Update title to:  
 Grading and Erosion Control Plan  
 Tom Shaffer Airplane Hangar Building  
 El Paso County, Colorado

# TOM SHAFFER AIRPLANE HANGAR BUILDING

This document will be reviewed as the standalone Grading and Erosion Control Plan. On the resubmittal upload to the "Grading and Erosion Control Plan (24 x 36)" slot.

SHEET NO. <b>C-0</b>	<b>TOM SHAFFER HANGAR STORAGE FACILITY</b>		FOR REVIEW	<b>CCP, LLC</b> 14255 JUDGE ORR RD, PEYTON, CO 80831
	PN: 19-1	DATE: AUG 2019		
<b>PLOT PLAN - 8136 CESSNA DRIVE</b>

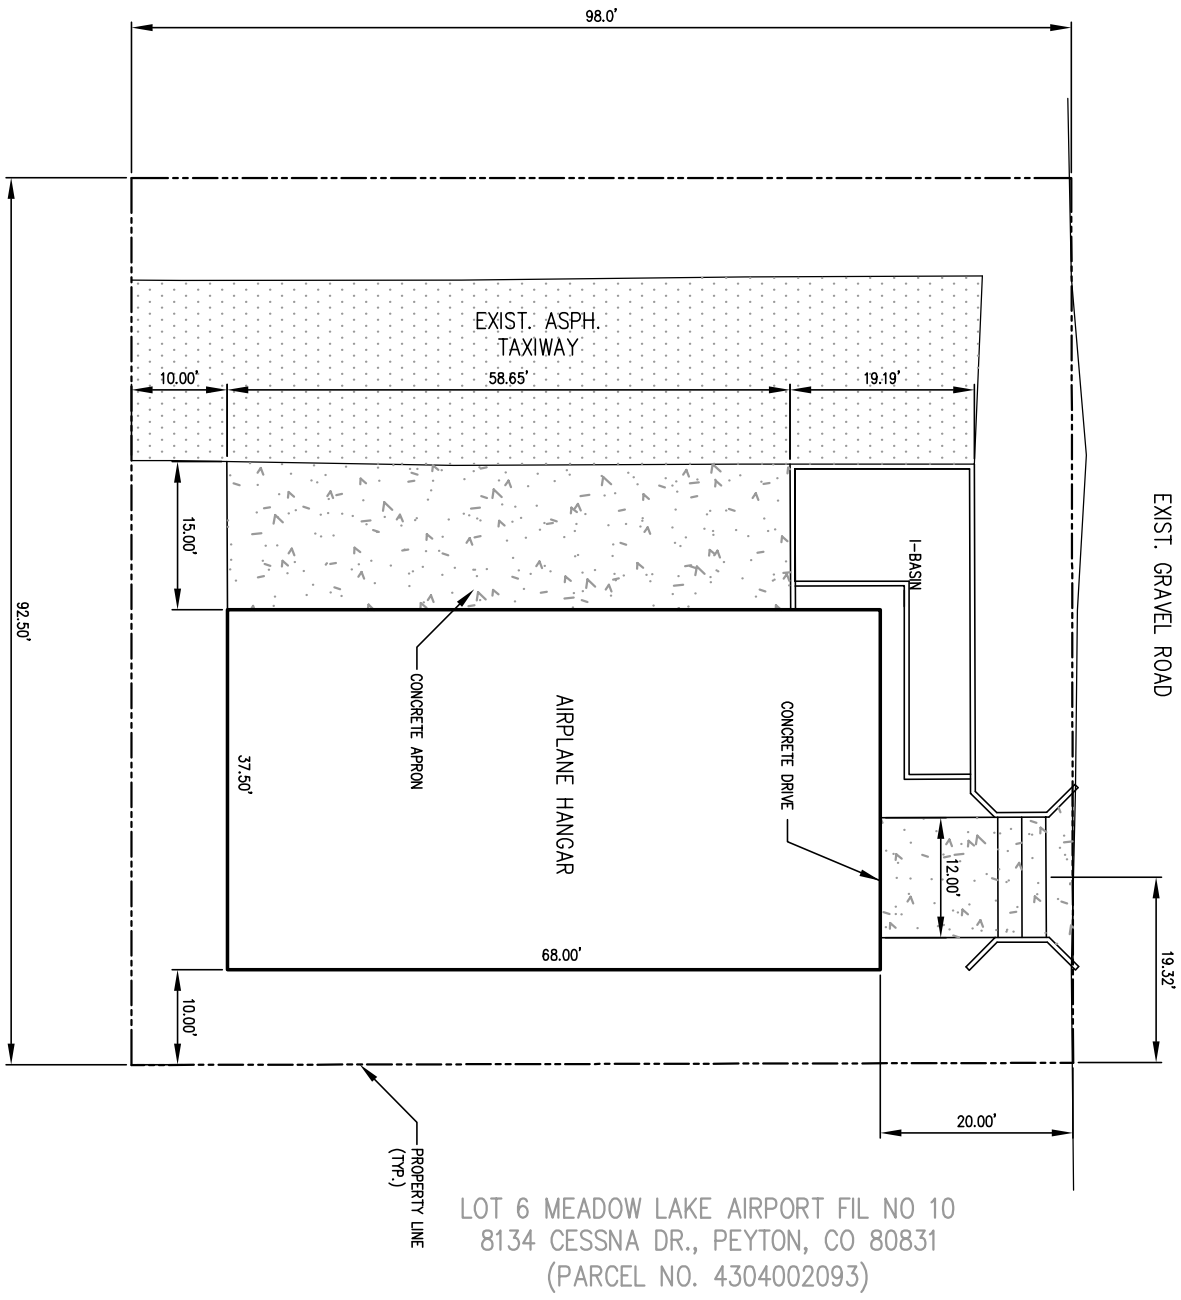
Remove from the  
 standalone GEC

SHEET NO. C-4

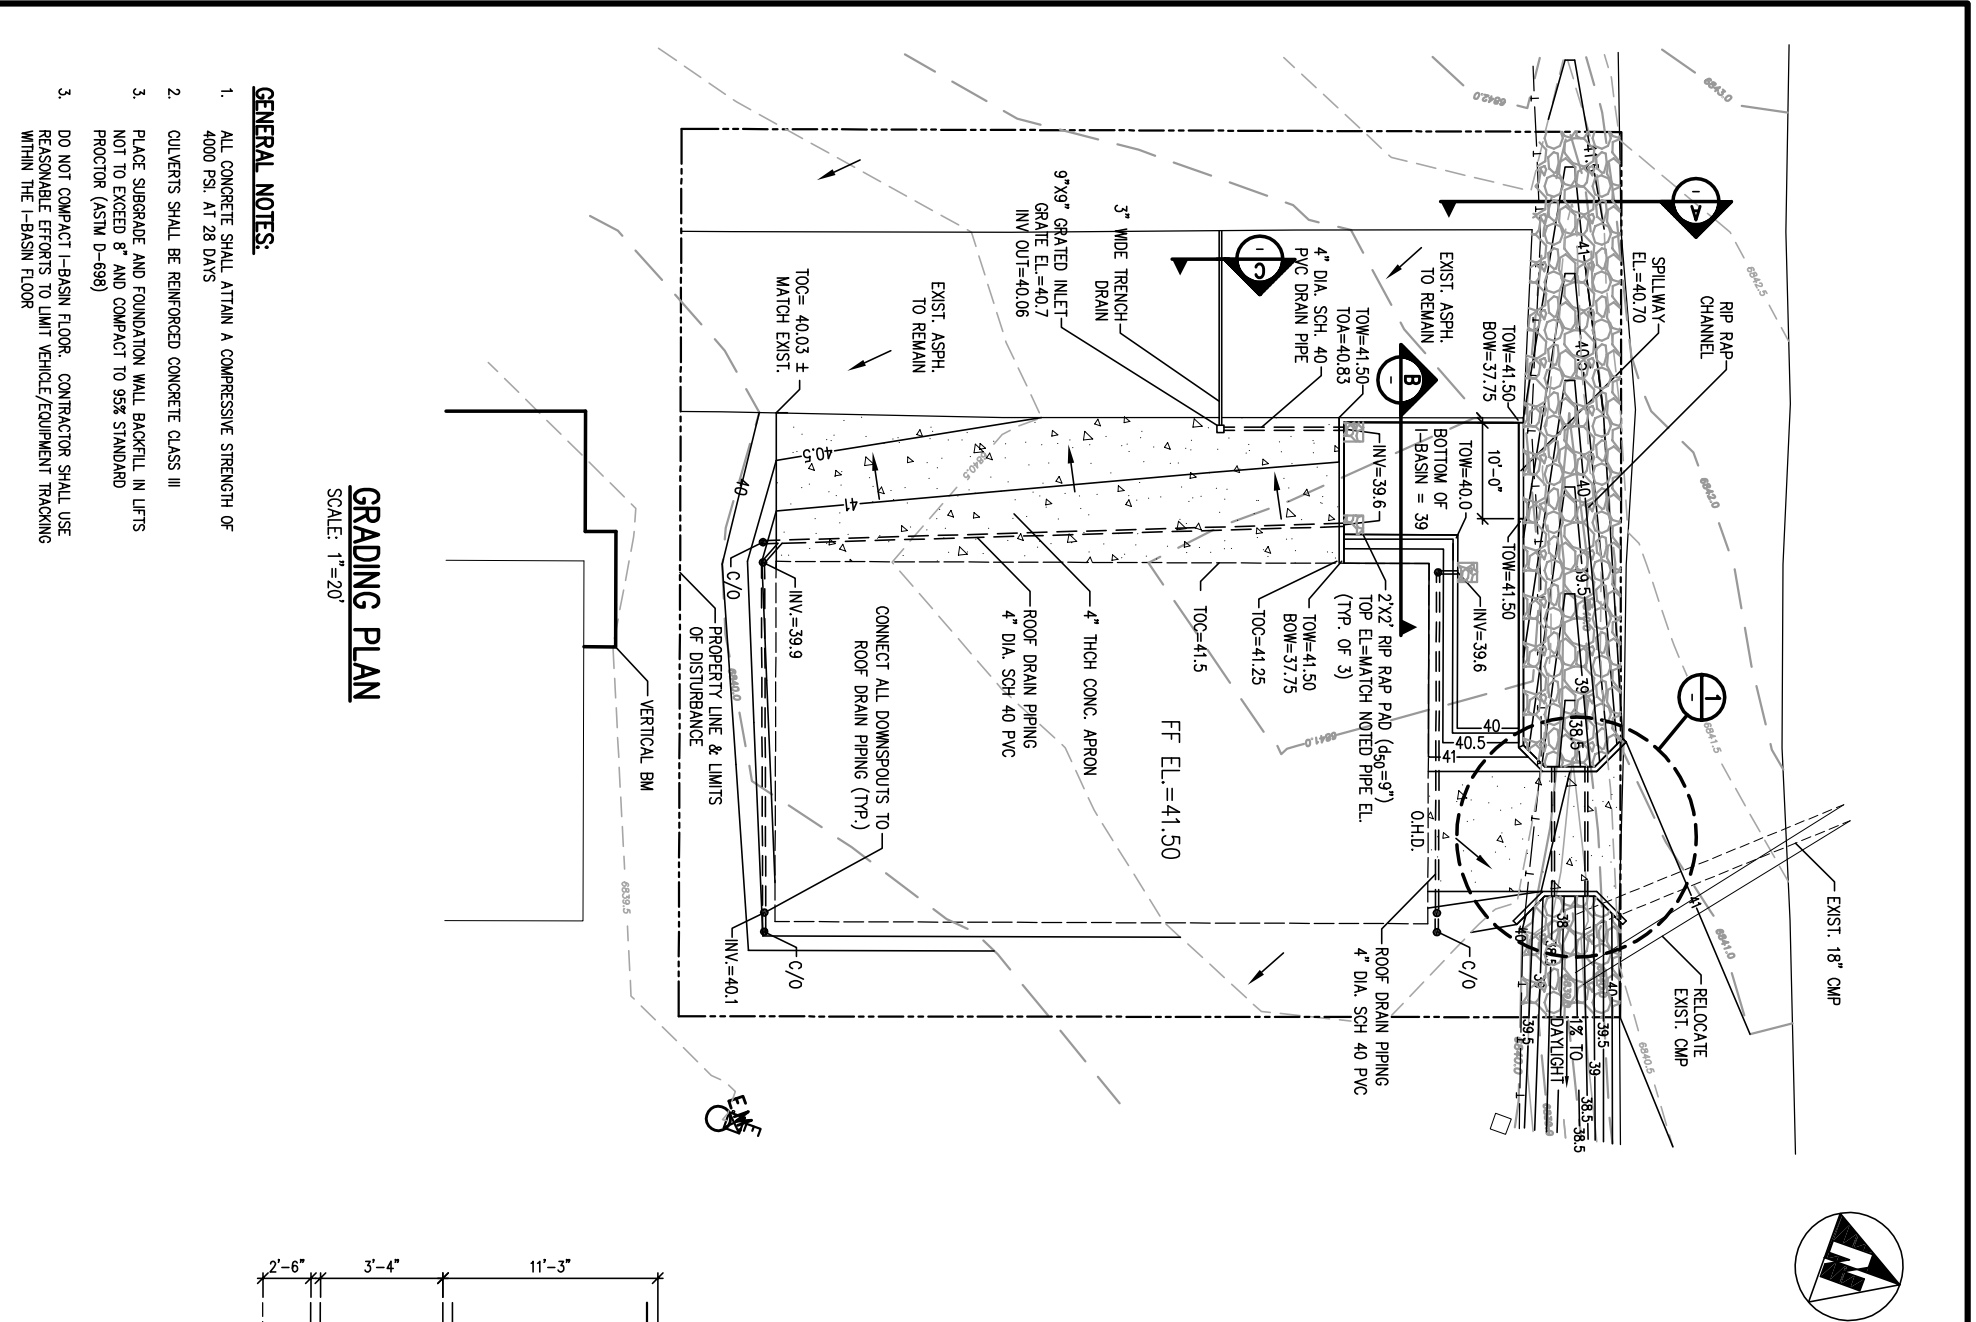
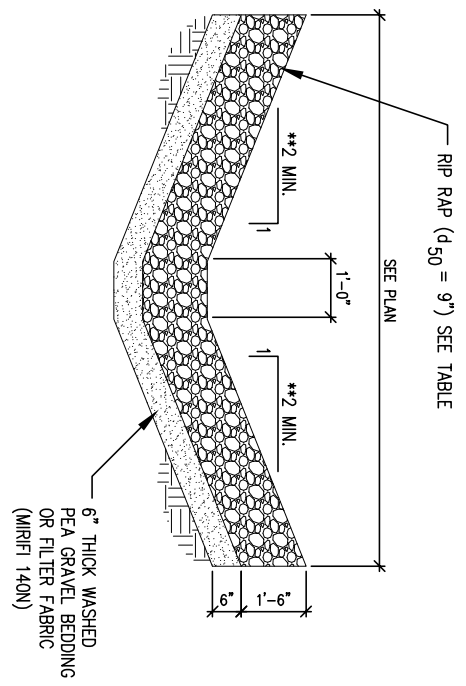
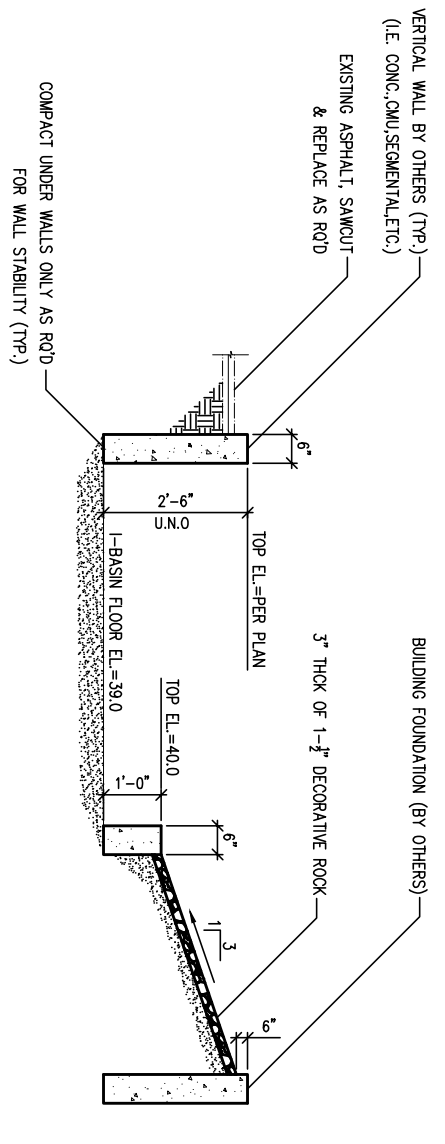
Label the adjacent parcel number/owner

Move cross section to the highlighted section and extend to the building.

Identify the type of BMP. Based on the O&M included this is intended to be a Sand Filter.

Show and label all existing easement

Show and label the WQCV and 100yr water surface elevation. Per UDFCD when SF are located adjacent to buildings or pavement areas, protective measures should be implemented to avoid adverse impacts to these structures.

add a distance label from the retaining wall to the building.

Provide details for the filter material. See UDFCD Volume 3 for criteria.

Include the roadside ditch hydraulic analysis in the drainage letter.

include the culvert analysis in the drainage letter.

Label the adjacent parcel number/owner

Label the adjacent parcel number/owner

Label property line bearing and distances

**EROSION CONTROL PLAN**  
SCALE: 1"=20'

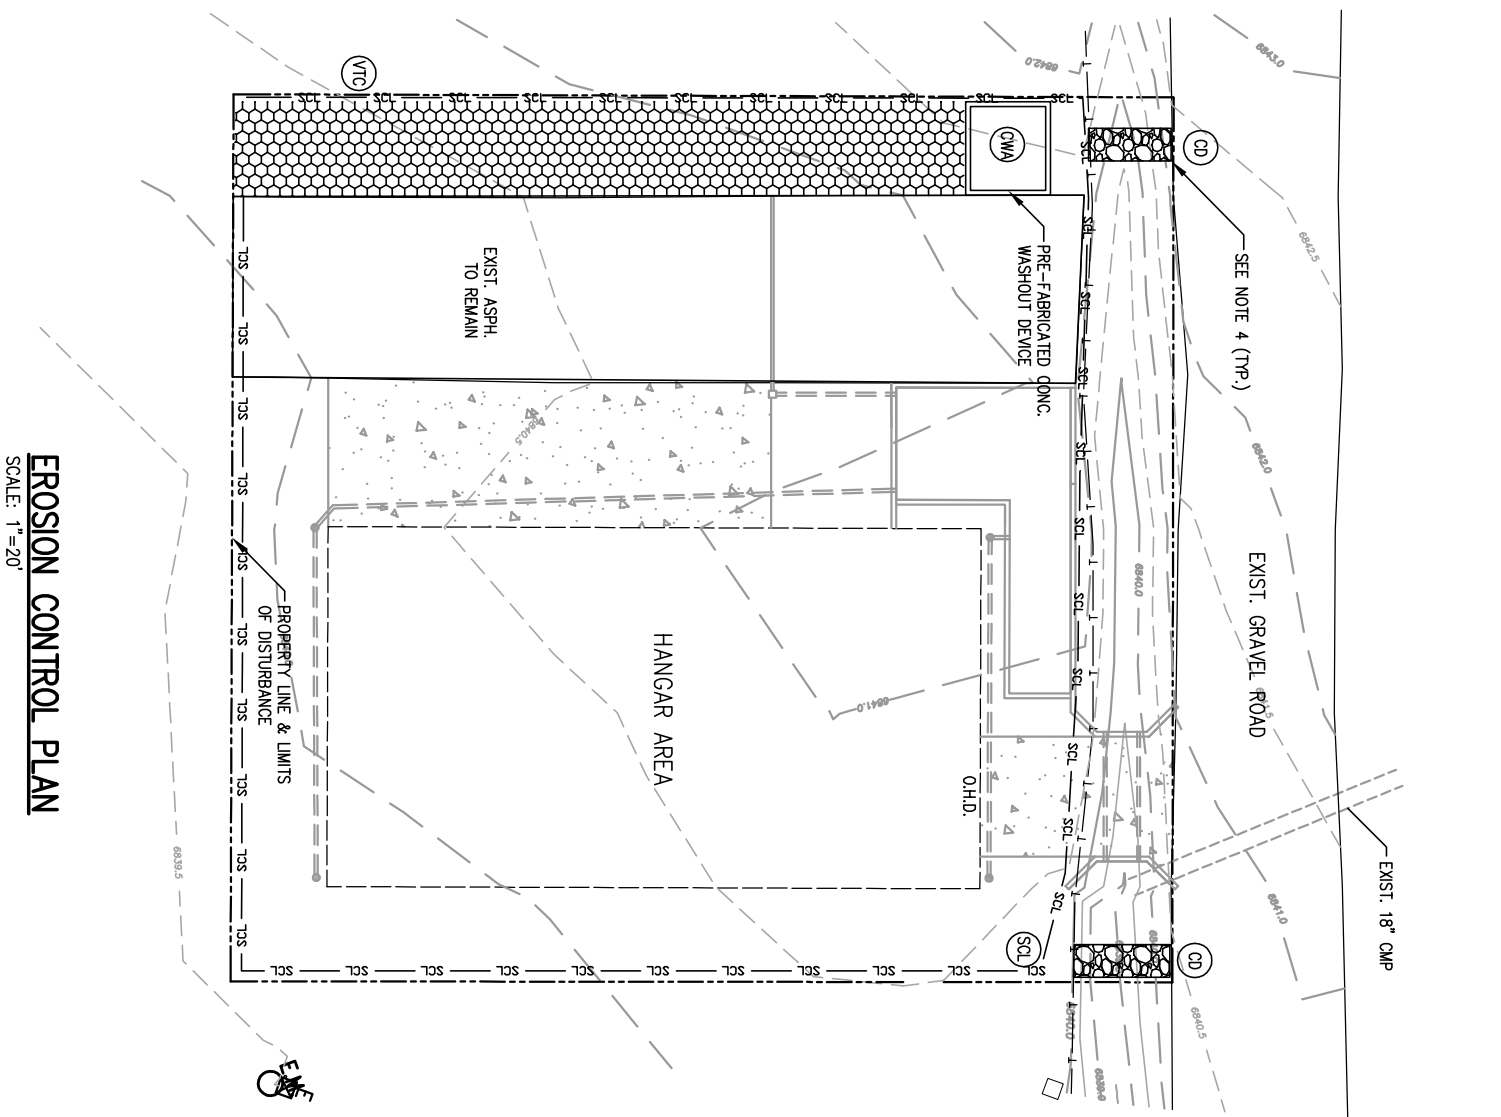
No note 4 on this sheet. Update and reference the relevant sheet note 4 is located.

Explain on the SWMMP narrative why the VTC is located at the side of the road. Staff's recommendation is to use an different type of VTC. Review Appendix F of the recent ECM update which identifies three additional approved VTC system.

It this VTC design is used, install a barricade at the highlighted area. Construction vehicles must be on the existing asphalt when it leaves the property to reduce potential damage on the adjacent properties landscape area. Add the barricade in the financial assurance estimate (FAE)

Identify the area used for staging, storage of building materials, stockpile. See checklist item 1u.
